**Consultation Response from KC,
Highways Development Management**

2023/93464 Land at, Lingards Road, Slaithwaite, Huddersfield, HD7 5HY

Date Responded:14-2-2024.

Appendix 3 – Construction Access and Site Compound

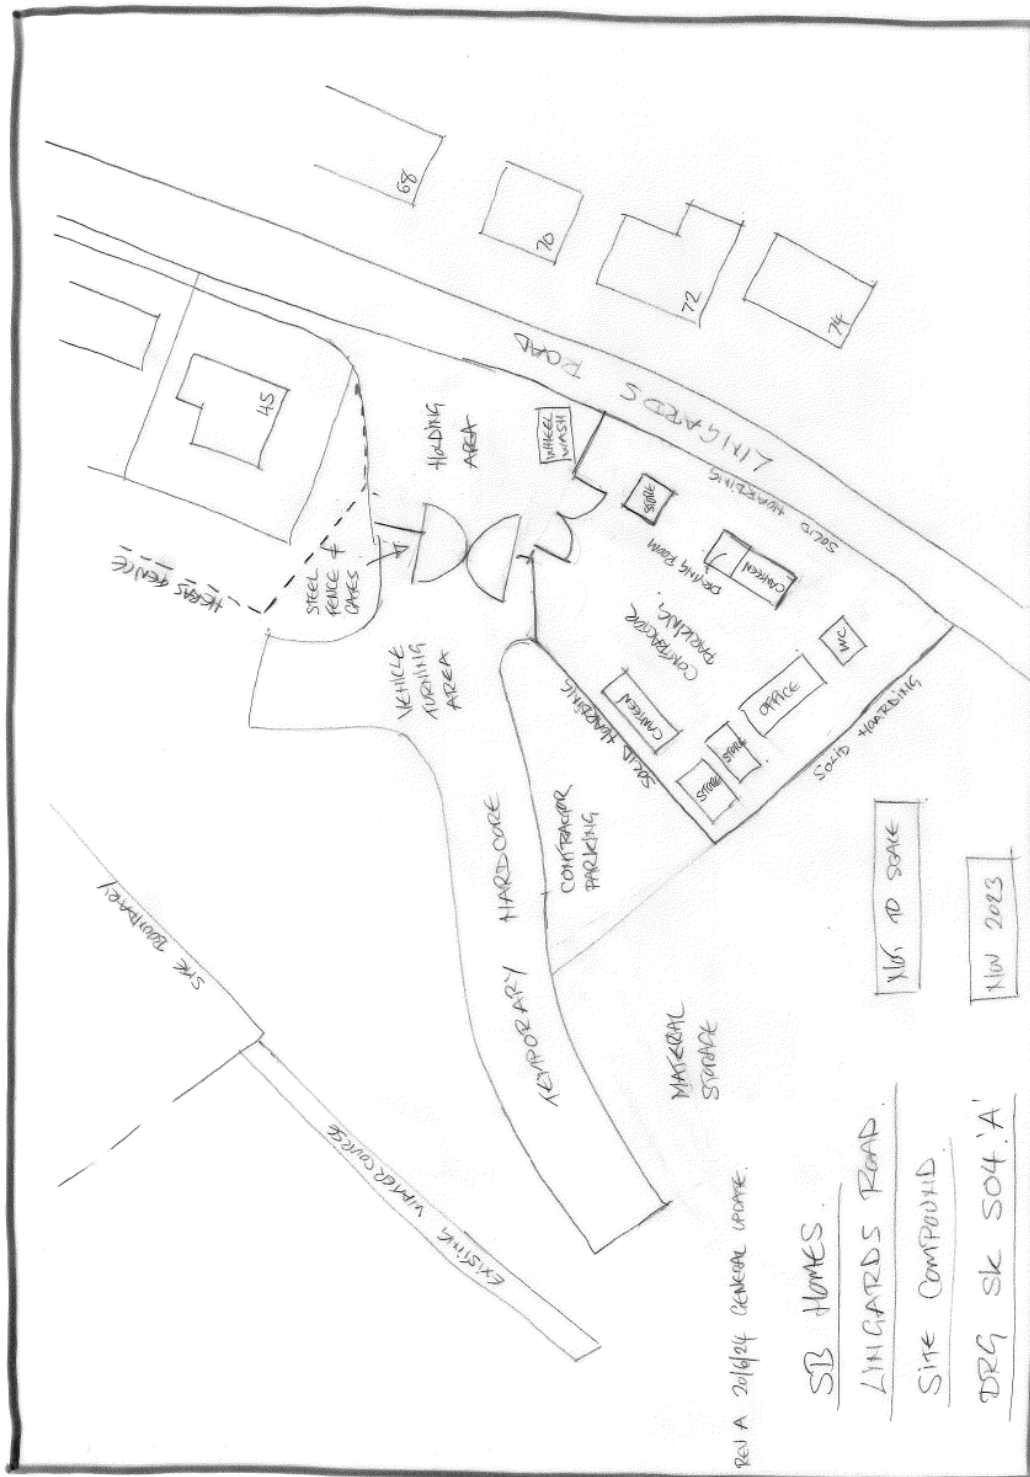
The applicants' proposals are considered acceptable to Highways Development Management other than the routing of construction vehicles should not use Lingards Road to the south from Chain Road. This length of road is steep and narrow with no footways and not ideally suited to HGVs. The junction with Chain Road is also sub-standard with poor sight lines.
